MDT-PUDSP22005-R2-PUDSP Plan redlines.pdf Markup Summary

SP03

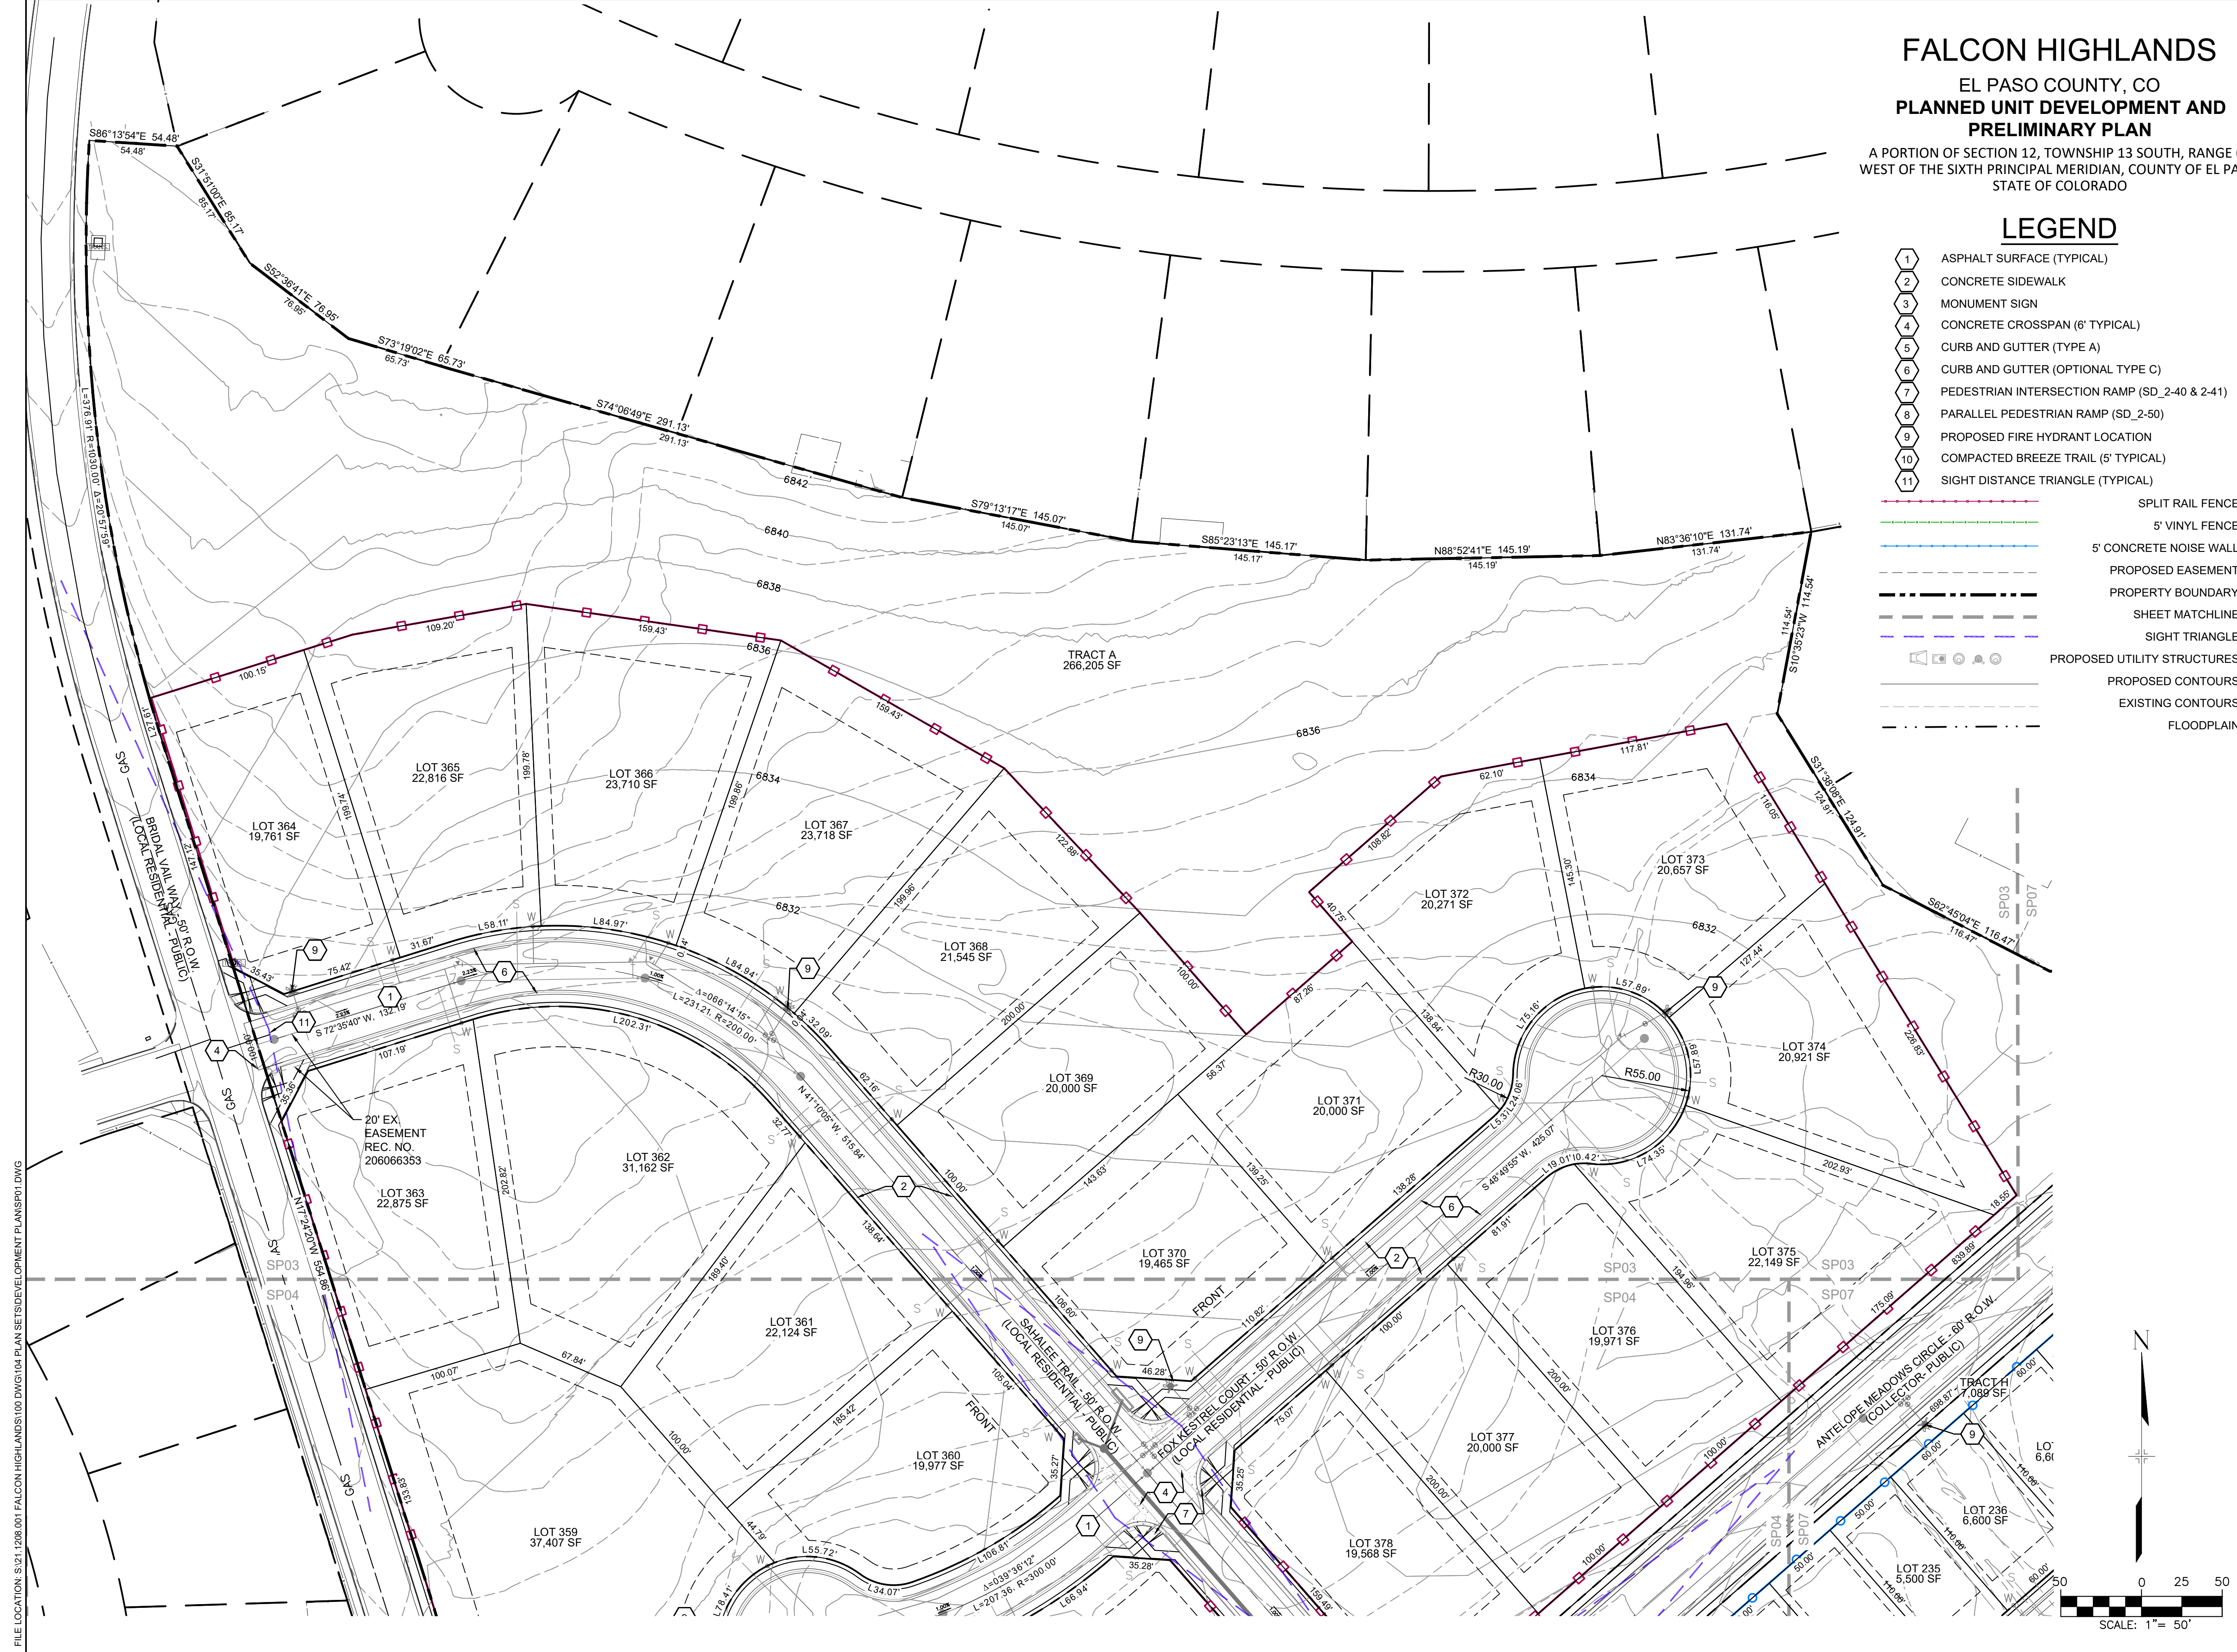
Label slopes as done in first submittal

fix overlap

SHEET 8 OF 31

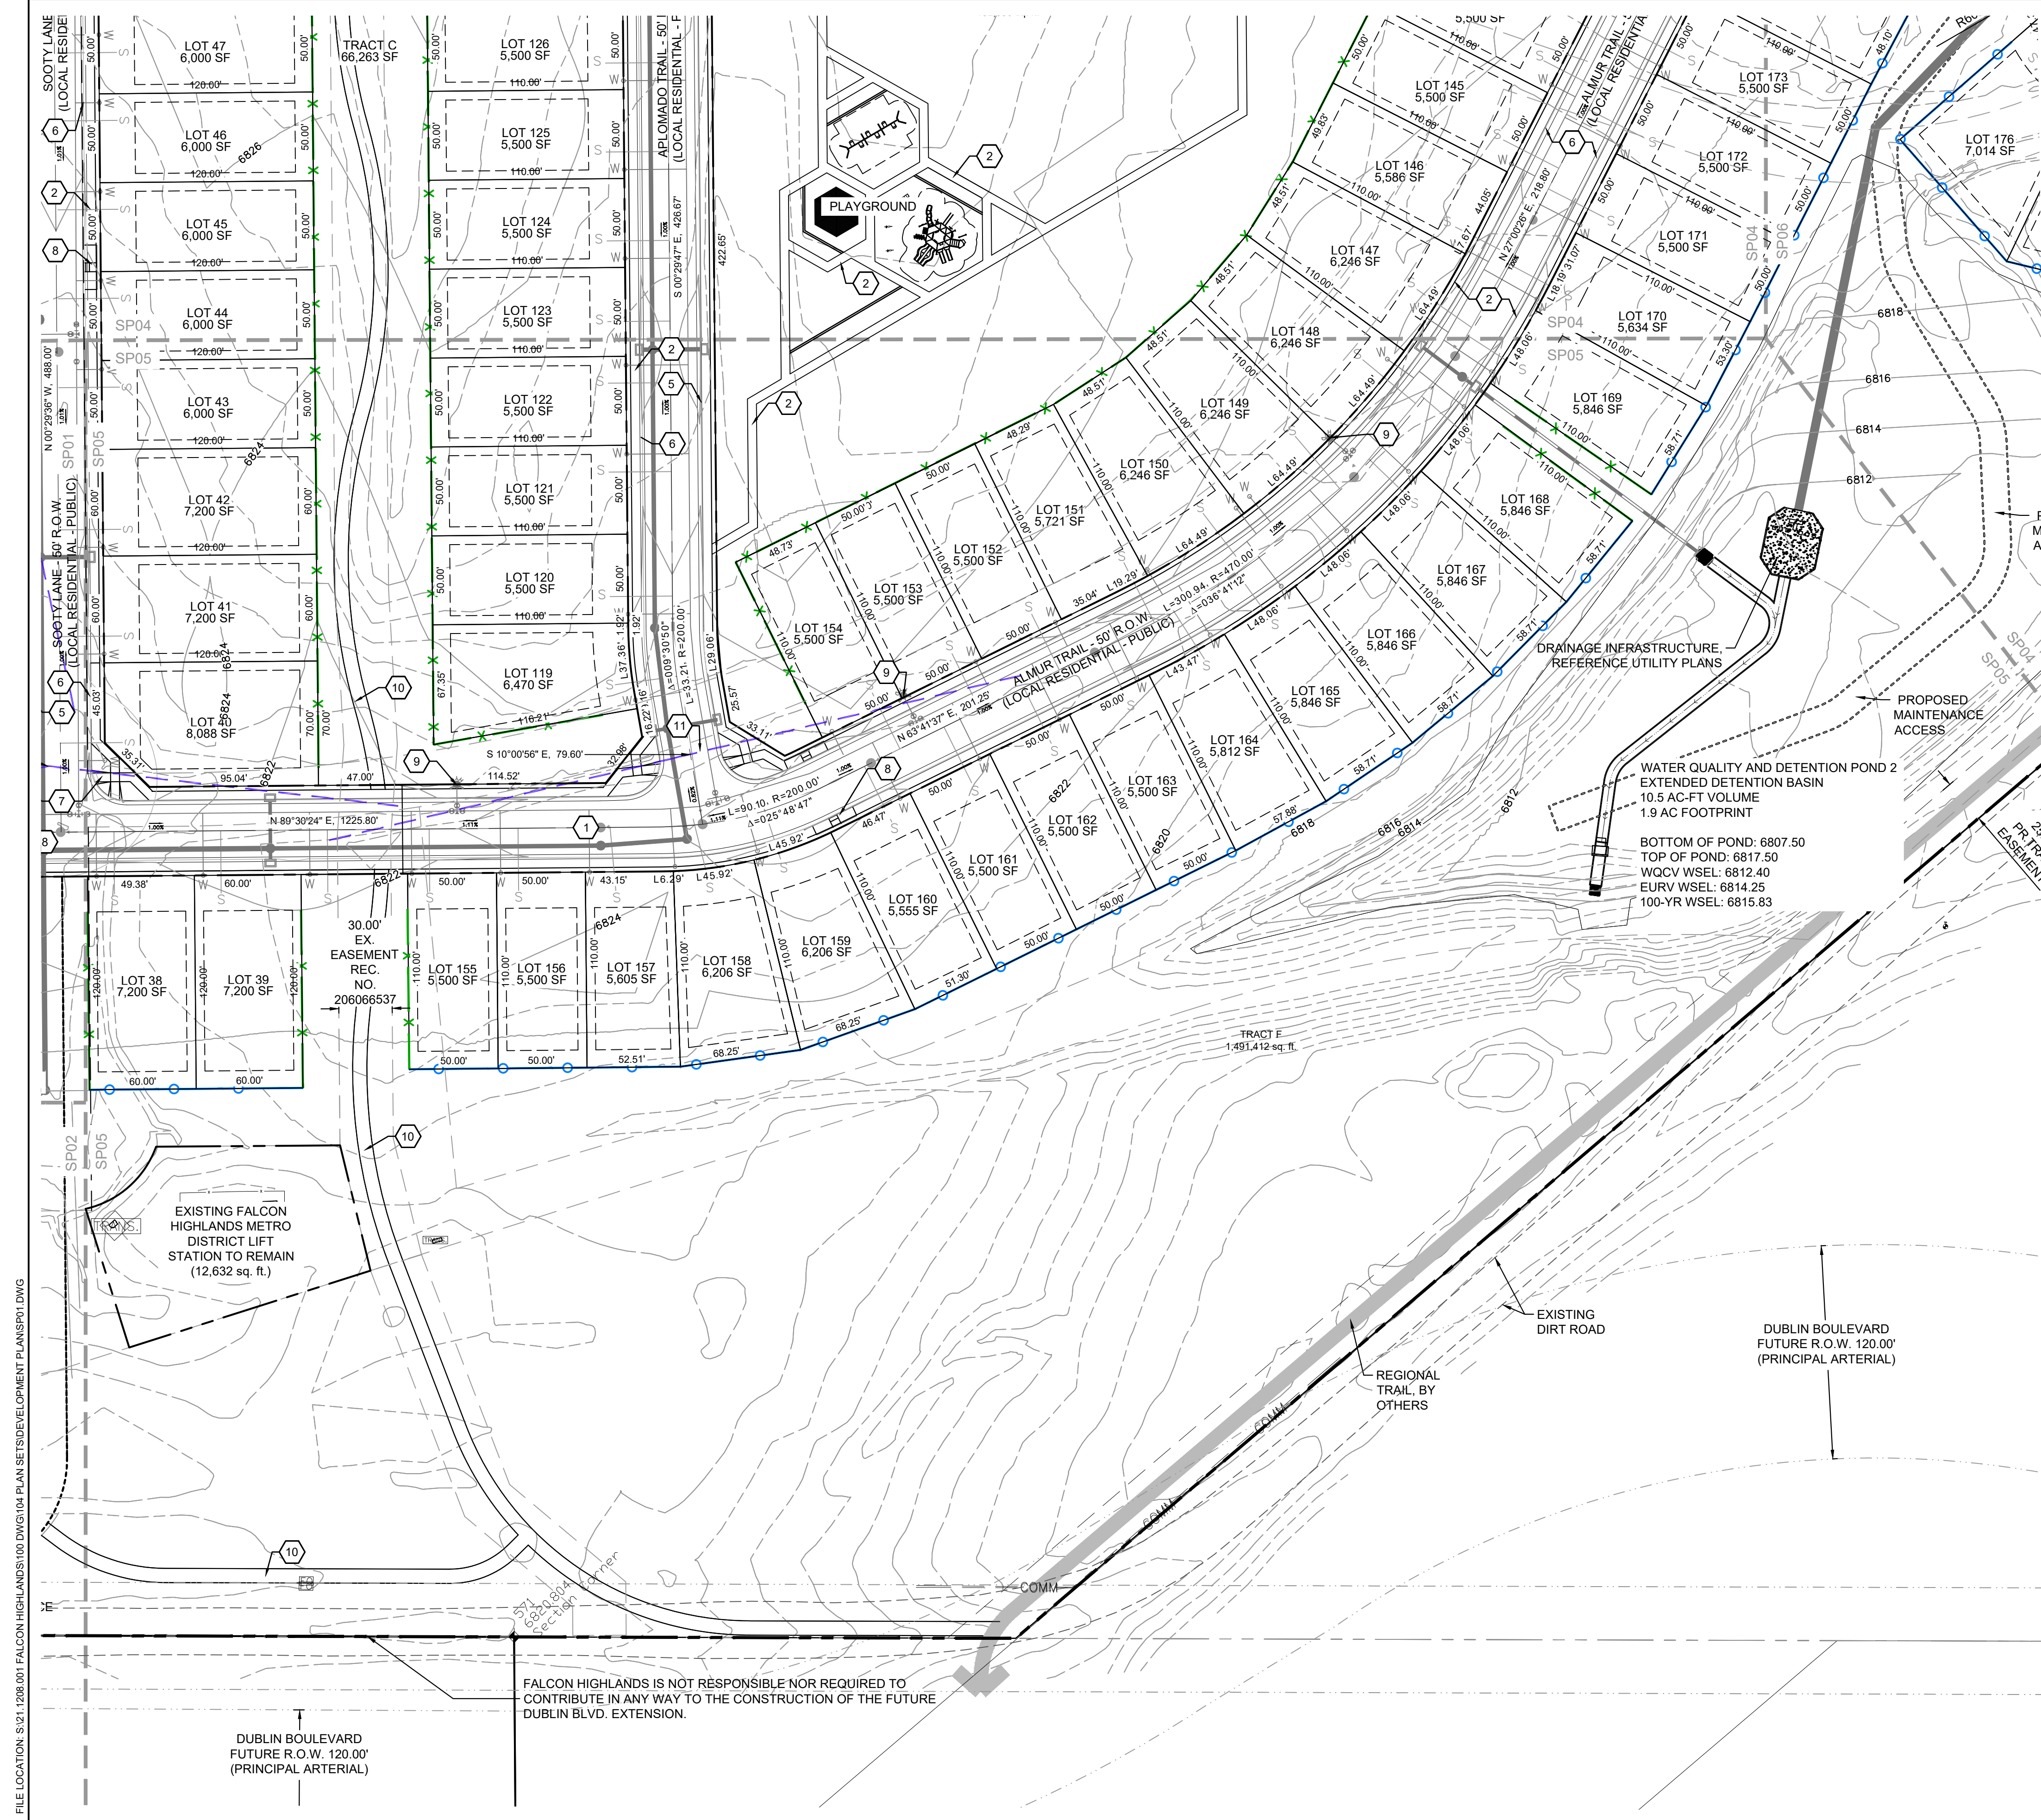
Per ECM SD_2-77 knuckle radius should be 50' for a local road.

fix overlap

SP05

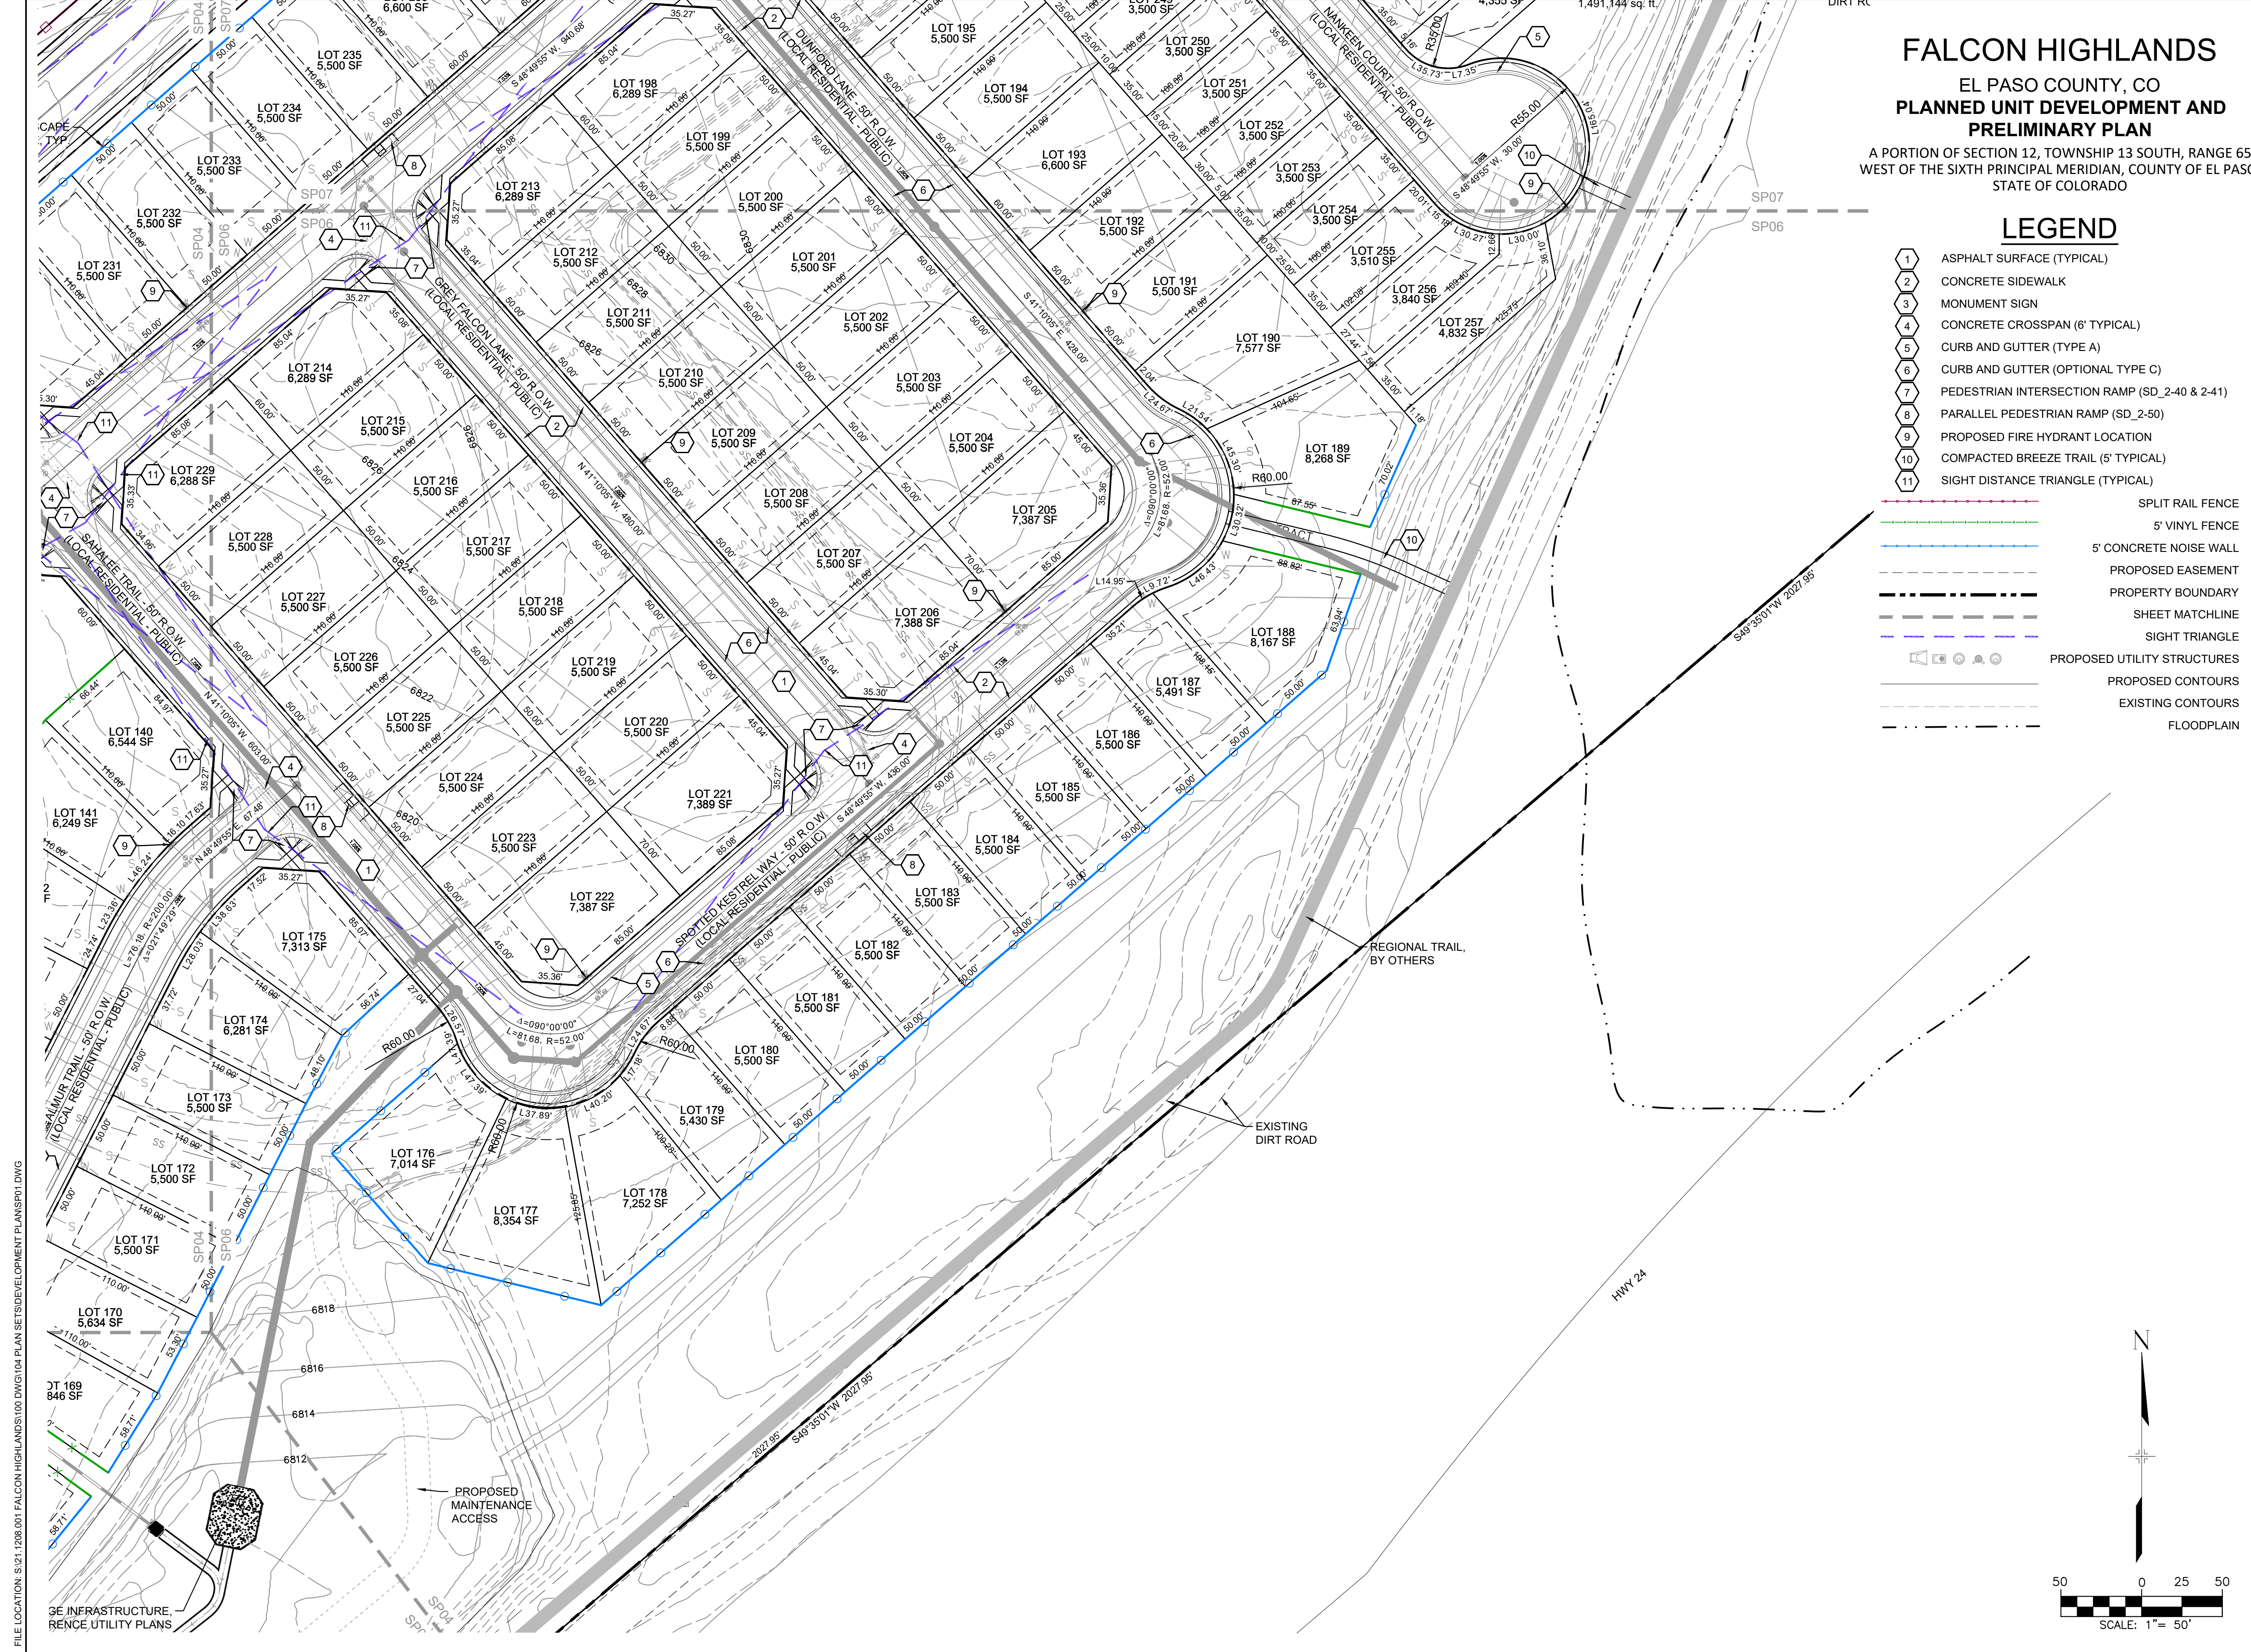
Label all drainage facilities.

Label linetype

Show the conceptual alignment of Dublin Boulevard.
